July 18, 2019

Re: Structural Certification
10', 12', & 16' Organizer Sheds

FLOOR PLAN

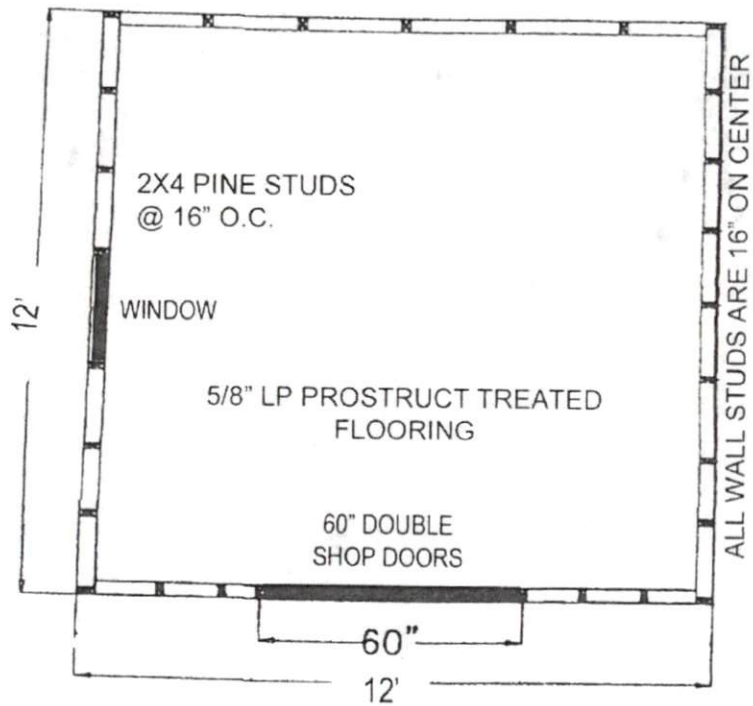
Wood stud headers over openings not exceeding 6'-0" in the end walls (non-load bearing) shall be (2) 2x4 studs bearing on a single 2x4 jack stud at each end. Headers over openings not exceeding 6'-0" in the side walls (load bearing) shall be (2) 2x6 studs bearing on double 2x4 jack studs.

FLOOR FRAMING

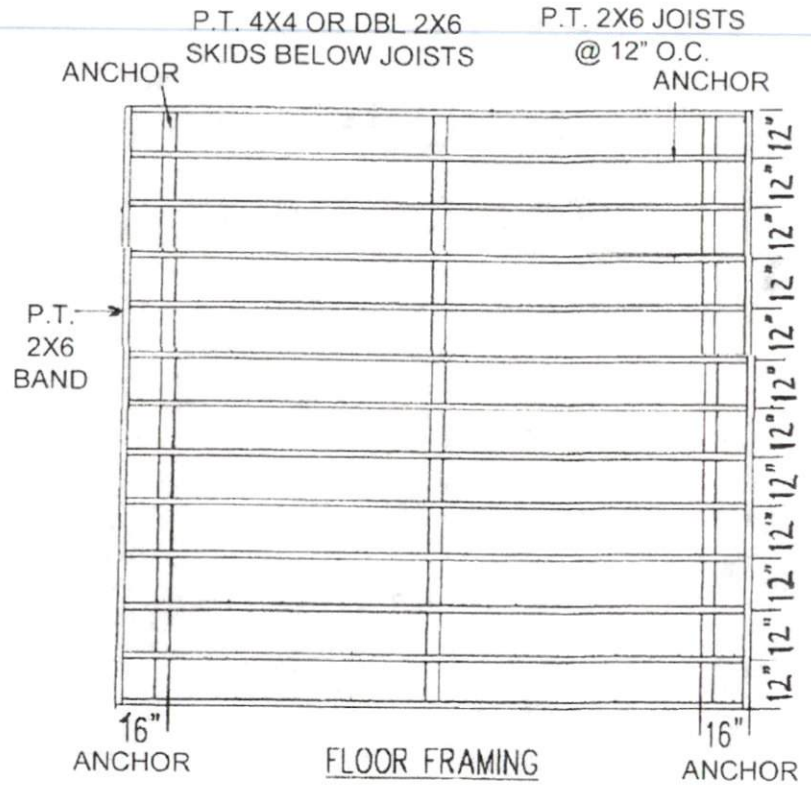
The floor framing consists of 2x6 joists at 16" on center supported on three (3) 4x4 "skids". Please be advised that the 2x6 floor joists can have a maximum of 10 1/2" cantilever beyond the 4x4 supports. Furthermore, please be advised that the 4x4 skids must be intermediately supported by piers at a maximum of 4' on center. Alternatively, if a double 2x6 beam is used for the skids, they must be supported at a maximum of 5' on center. The skids may bear on 8"x16" CMU piers which bear directly on the soil. The piers may be constructed with dry stacked concrete masonry units, with solid units top and bottom and hollow 8" concrete

masonry units for the remainder of the pier at a maximum height of 36". The floor framing should be tied down with 30" screw anchors and 1" metal strapping across the floor joists.

ROOF FRAMING

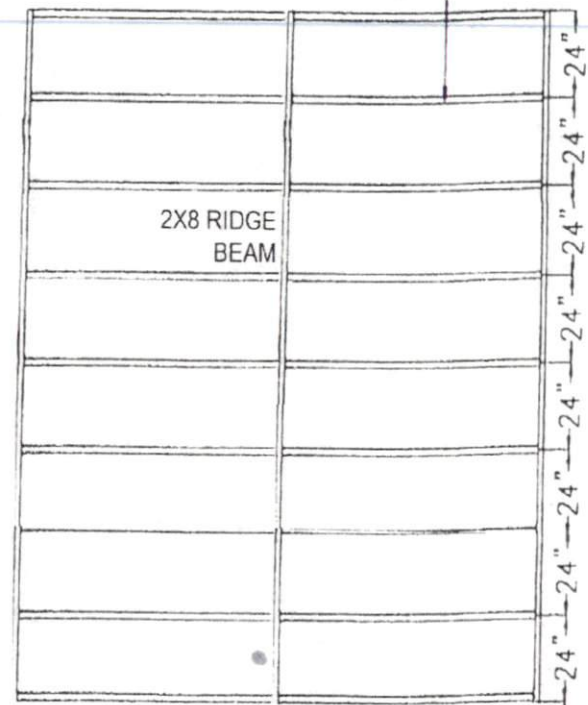
This variation consists of a 12' wide shed with a gable roof system. The roof consists of 2x6 rafters @ 2'-0" on center at a 5:12 or 9:12 pitch, and the walls are constructed with 2x4 studs at 16" on center. Please be advised that the rafters shall be cross-tied with 2x4 collar ties located at the 1/3 point extending downward from the ridge and spaced at 4'-0" on center. A 2x ridge board shall be provided for the connections of the opposing rafters at the ridge. The collar ties should be attached at each rafter with a minimum of (8) 10d nails
